TO:	Arun District Council FAO: S Davis
FROM:	Highways, WSCC
DATE:	10 th December 2018
LOCATION:	66 & 66A, Hawthorn Road, Bognor Regis, West Sussex, PO21 2DD
SUBJECT:	BR/308/18/DOC Approval of details reserved by condition imposed under ref BR/293/16/PL relating to Condition No. 3 materials & finishes, Condition No 4 screen walls & railings, Condition No 5 refuse & recycling bin enclosure Condition No 7 covered & secure cycle parking spaces.
RECOMMENDATION:	☒ Advice ☐ Objection ☐ Modification ☐ No Objection ☐ More Information ☐ Refusal
S106 CONTRIBUTION TOTAL:	£N/A

West Sussex County Council, as the Local Highway Authority (LHA), has been consulted on discharge of conditions secured under approval BR/293/16 (change of use to 5 x flats). Condition 7 pertains to the provision of secure bicycle parking spaces.

## As Built Site Plan

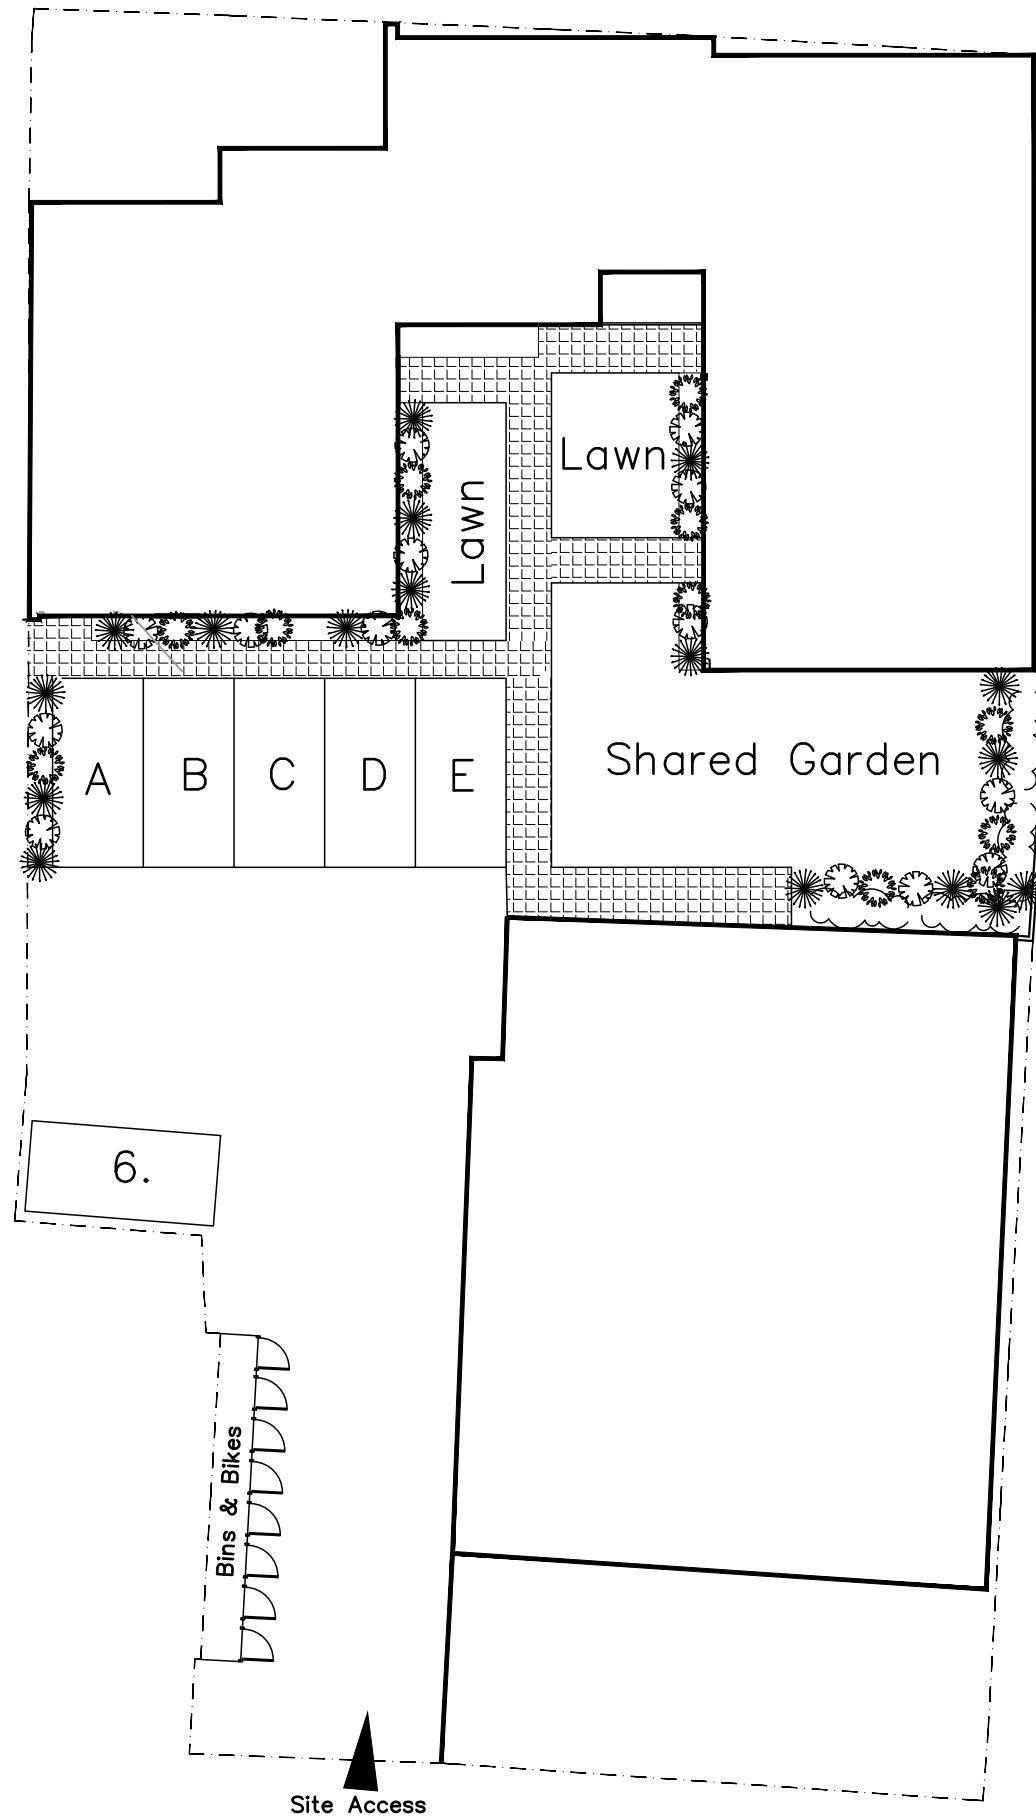
The As Built Site Plan indicates the shared bike and bin store. Whilst the internal dimensions and quantity of bicycle spaces are unknown it is evident there is sufficient space for secure and covered bicycle storage. The plans and details pertaining to the condition are acceptable.
